Date: 1-8-11

From: Roger Evans

Subject: Comments Former Cereal Partners site – Broadwater Road

03. EAST ELEVATION

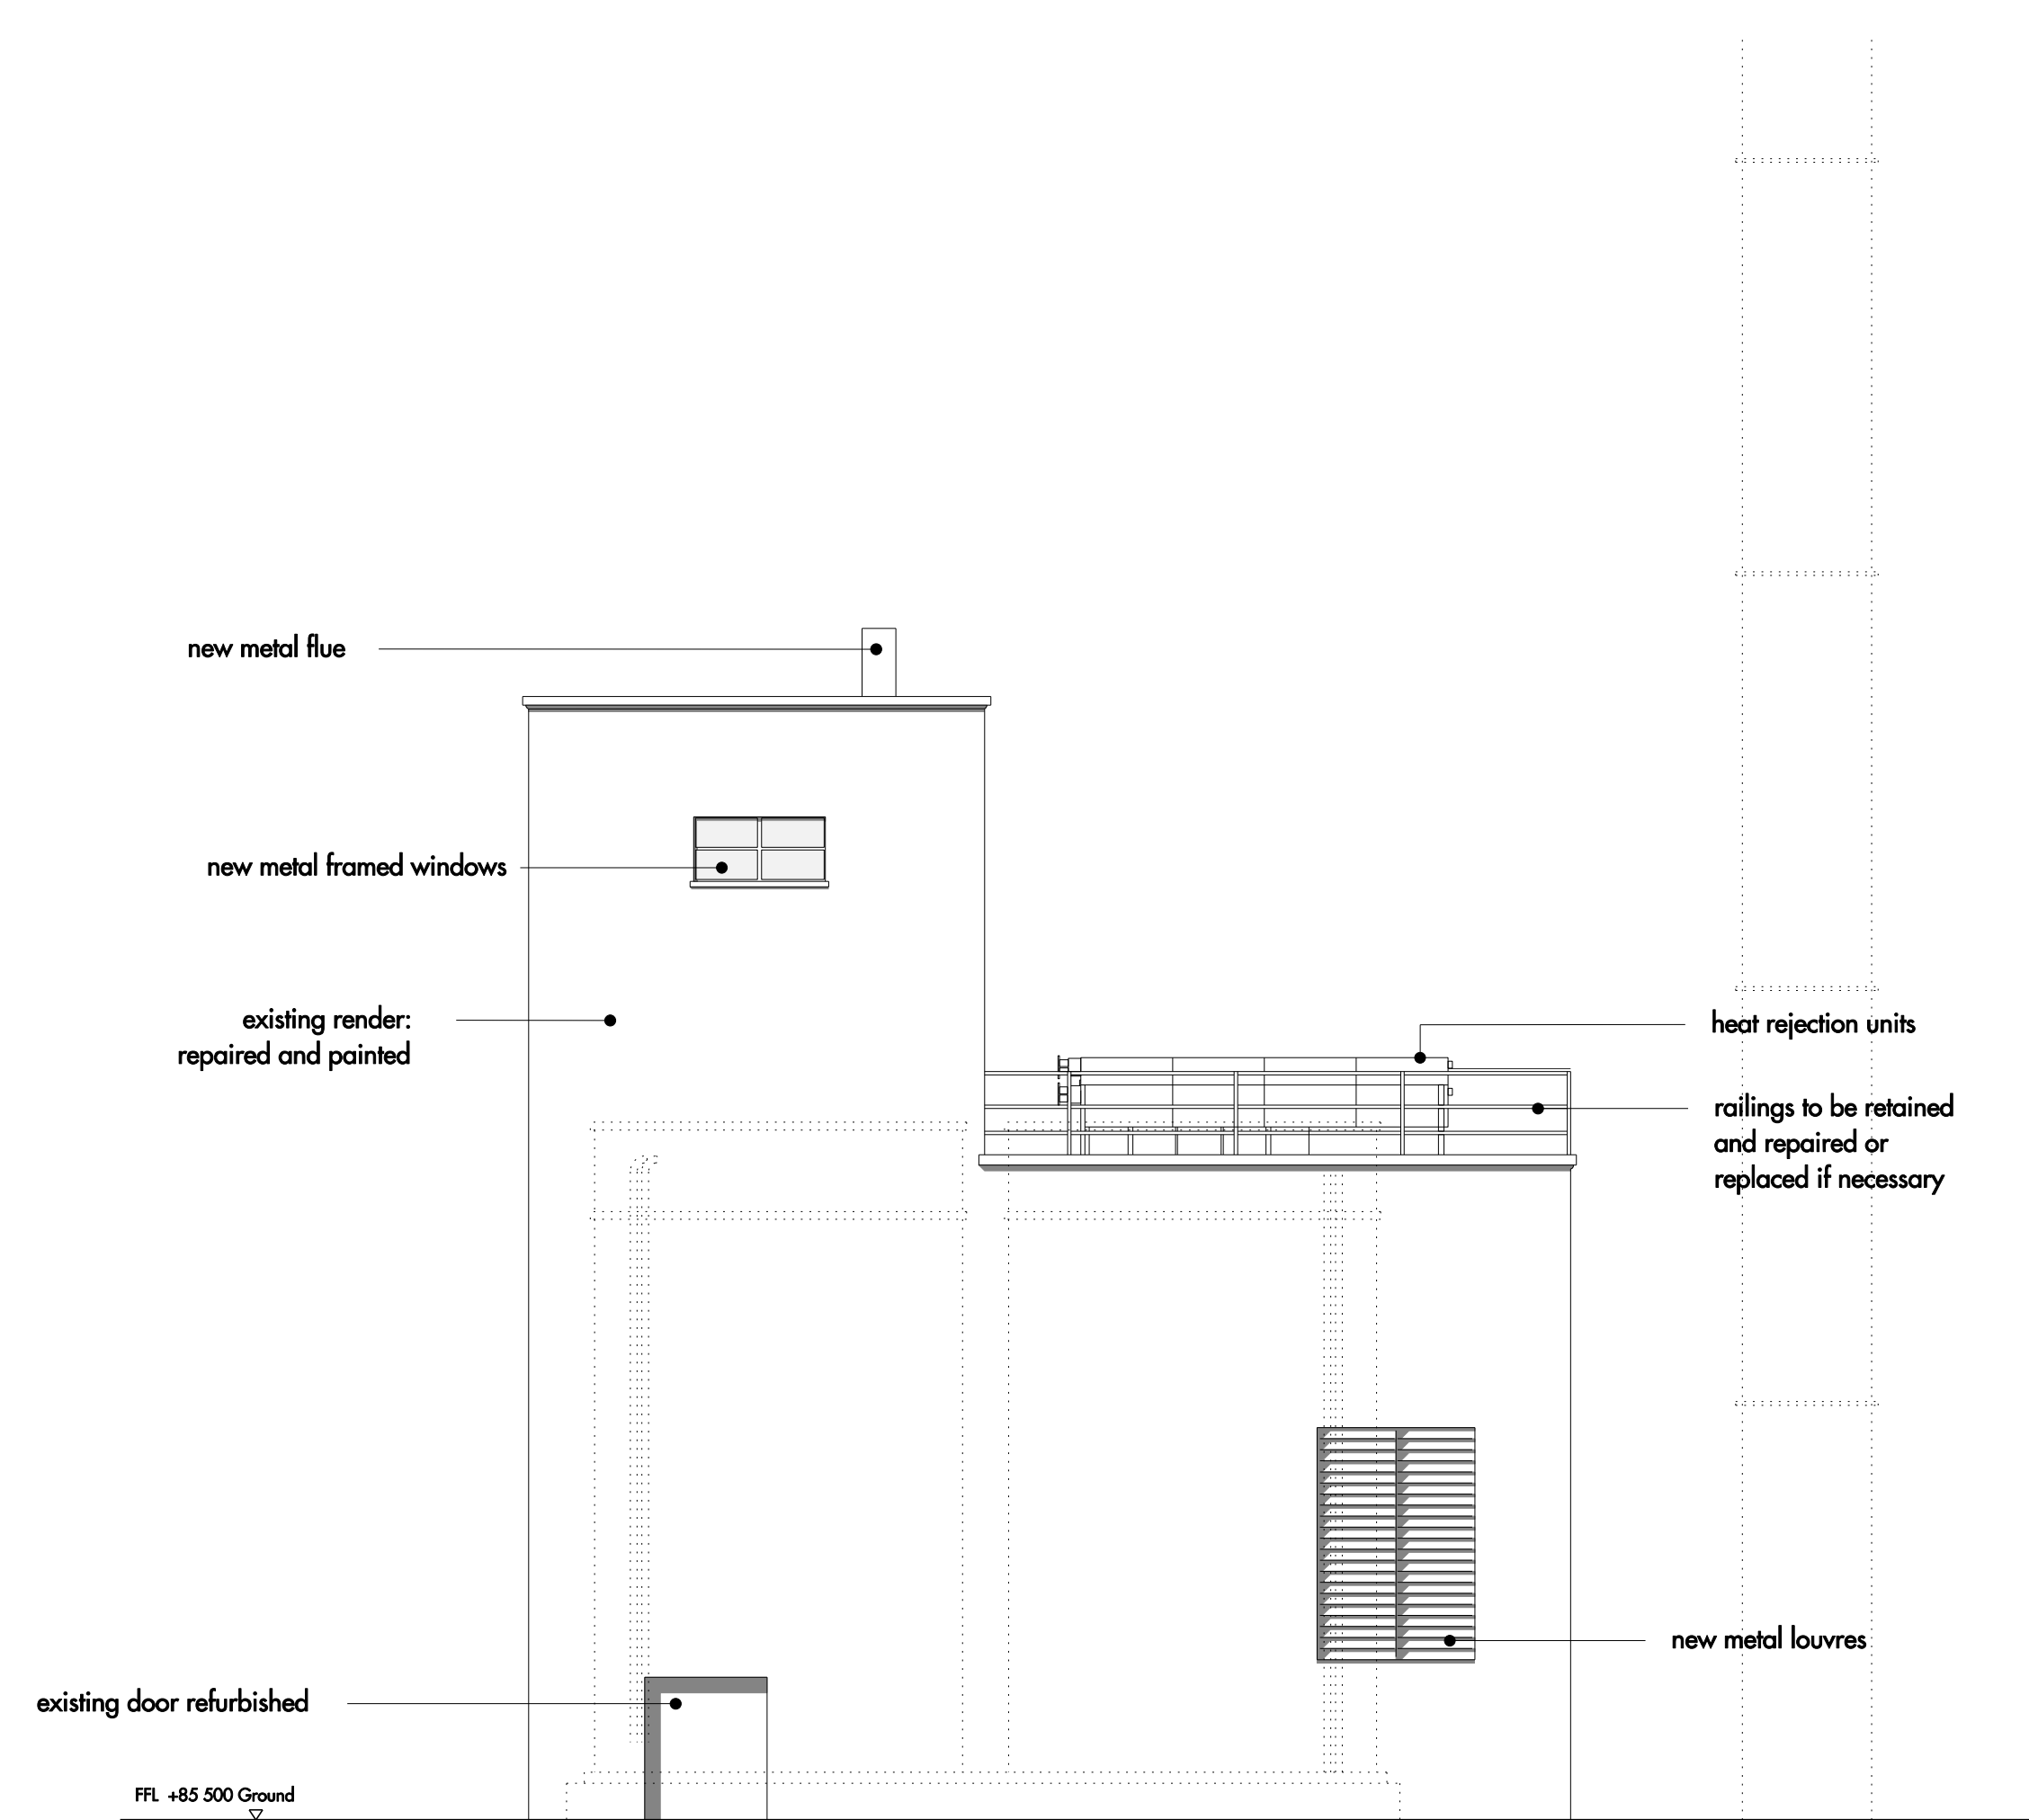
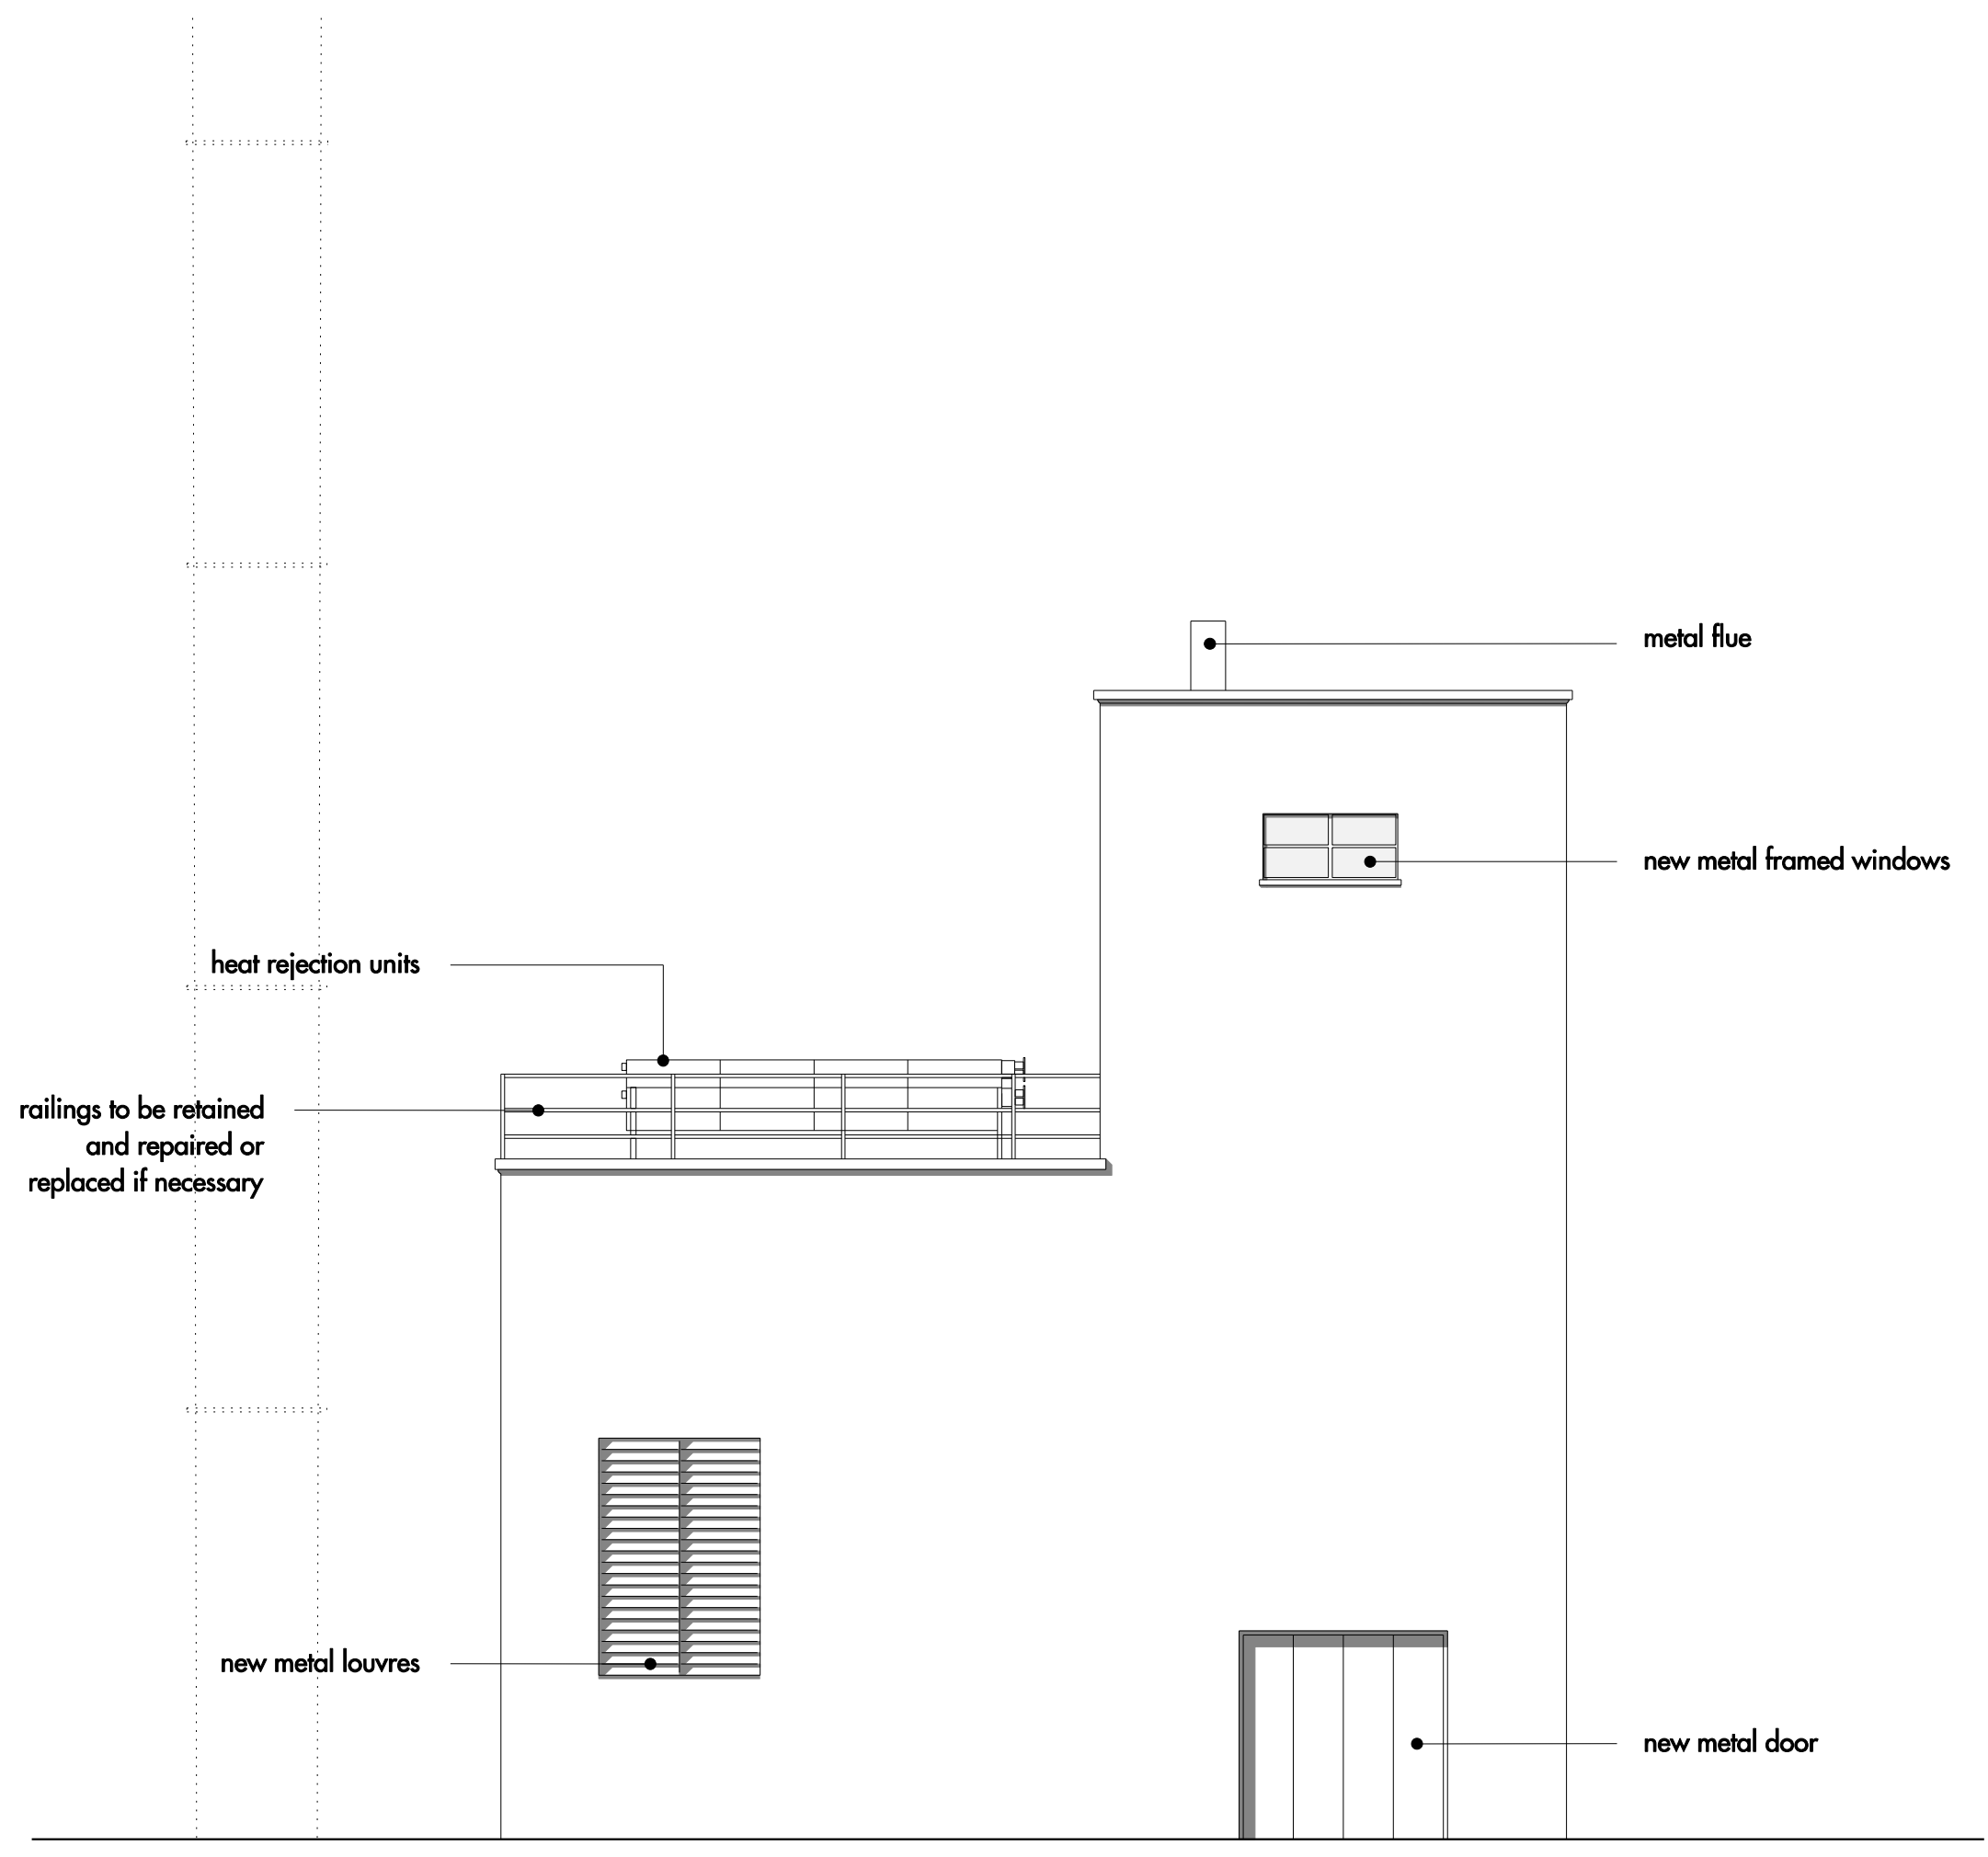
The assessment of noise from the CHP indicates that the “target” maximum noise level is 33 dBA at 10m from the building is achievable, based on information from the potential supplier. For this to be possible the two external heat rejection units will have to be “low noise” models capable of a maximum noise output of 30 dBA at 10m (consequently a combined level of 33dBA) . In addition the attenuation provided behind the louvers and to ventilation duct openings would need to be able to reduce the noise level from the remaining plant to 20dBA at 10m. *The combined total would not in this case exceed the 33dBA level required.* The output from the heat rejection units will be readily available, details of the performance of equipment to attenuate the louvers and the ventilation ducts will need to be provided .

Insofar as conditions are concerned I would suggest – A scheme of attenuation for the CHP should be submitted and agreed by the planning authority. This should indicate plant noise levels, including frequency analysis, and the attenuation details in respect of internal and external plant, calculated to ensure the noise level at 10m from the building, relating to the CHP operation, does not exceed 33dBA.
